STATE OF NORTH CAROLINA
DEPARTMENT OF TRANSPORTATION

Addendum No. 1

RE: Contract ID C202976
WBS # 17BP.6.P.2

Bridge #4 on NC-130, #13 on SR-1207, #70 & 72 on US-74, #96 on SR-1155,
#106 & 107 on I-95, #17 on US-701 and #147 on SR-1832

REVISIONS						SHEET NO.
NO.	BY:	DATE:	NO.	BY:	DATE:	S-7
1			3			TOTAL SHEETS
2			4			75

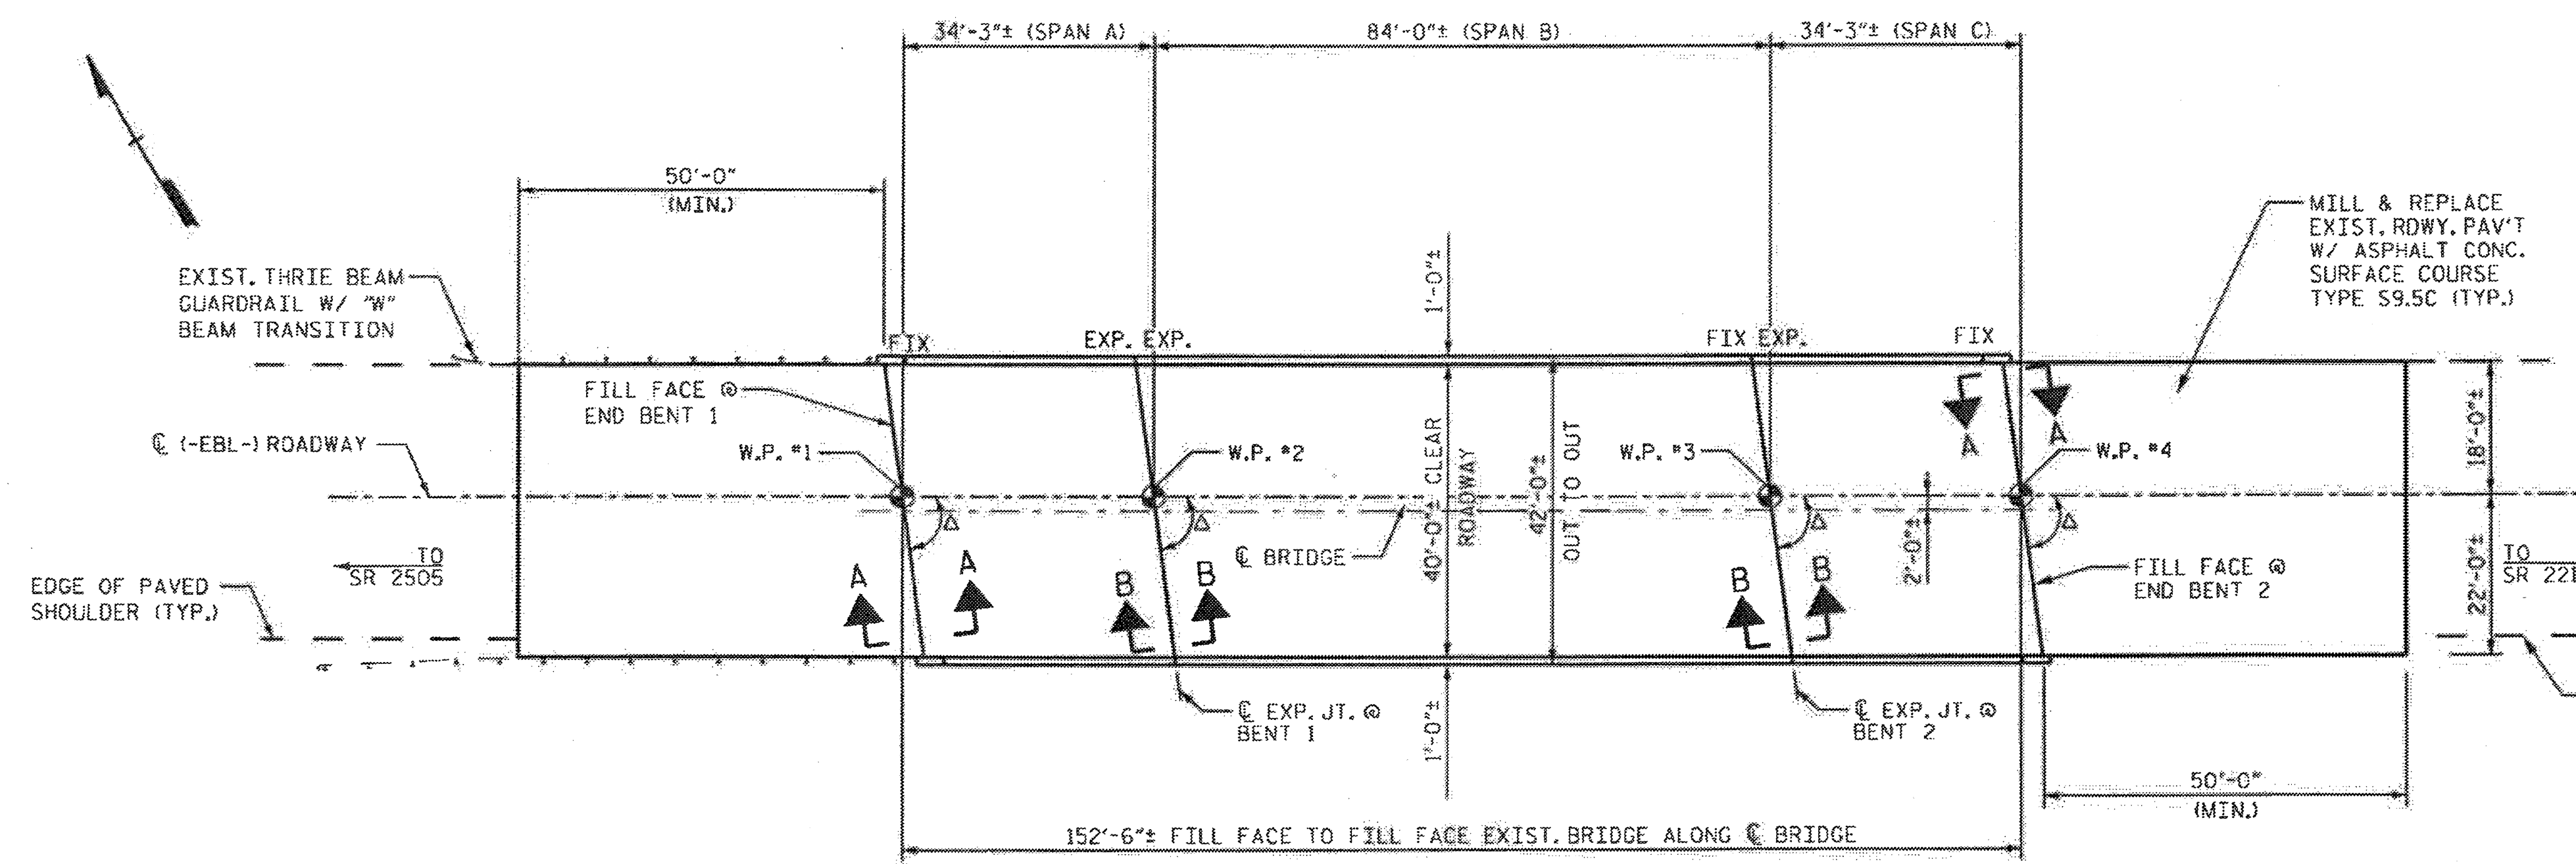
Sheet Nos. S-7, S-8, S-9, S-15, S-16 and S-17 have been revised to change "latex modified concrete" to "latex modified concrete-very early strength". Please void Sheet Nos. S-7, S-8, S-9, S-15, S-16 and S-17 in your plans and staple the revised Sheet Nos. S-7, S-8, S-9, S-15, S-16 and S-17 thereto.

REVISIONS						SHEET NO. 5-44
NO.	BY:	DATE:	NO.	BY:	DATE:	
1			3			TOTAL SHEETS 75
2			4

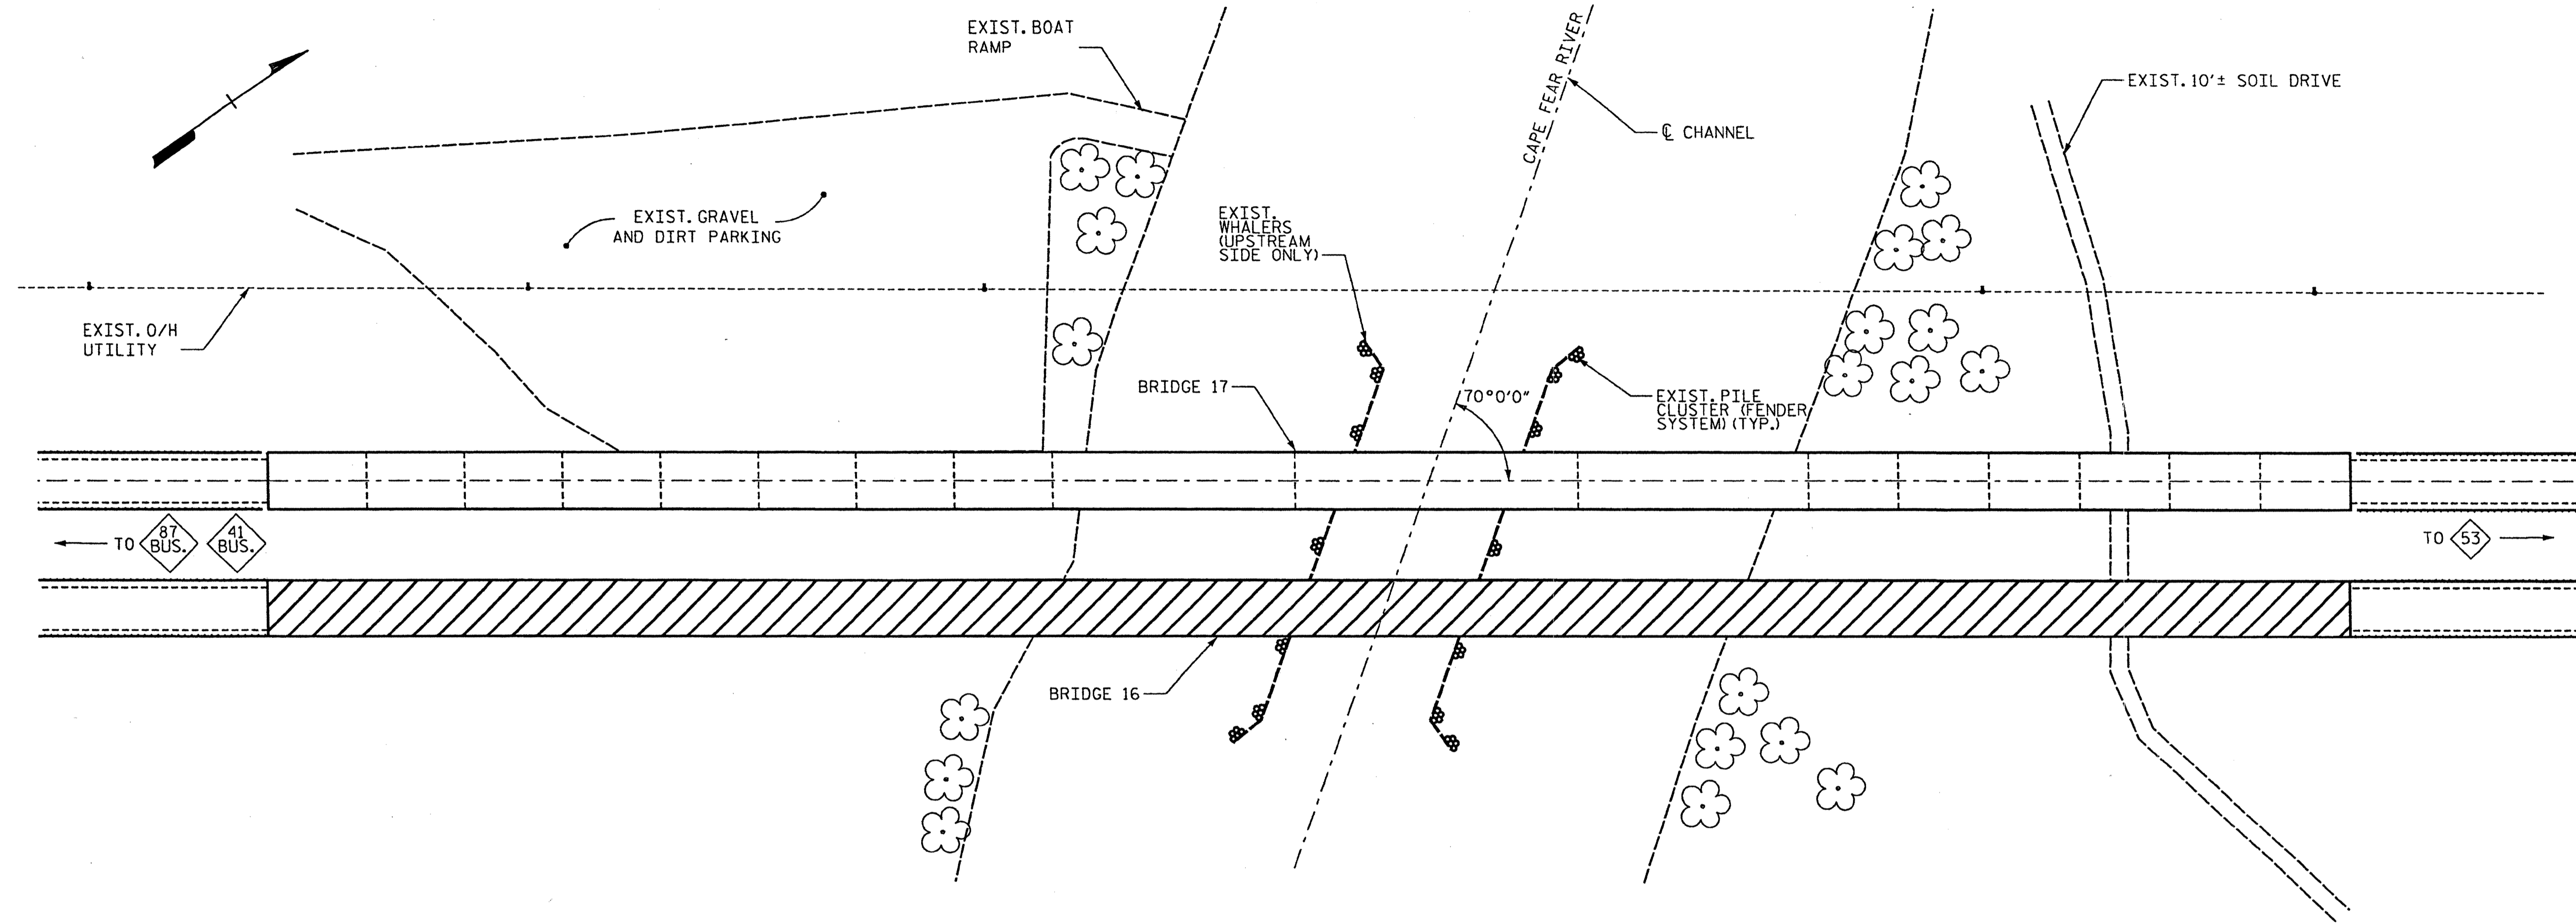
On Sheet No. S-44, Detail "D" has been revised. Please void Sheet No. S-44 in your plans and staple the revised Sheet No. S-44 thereto.
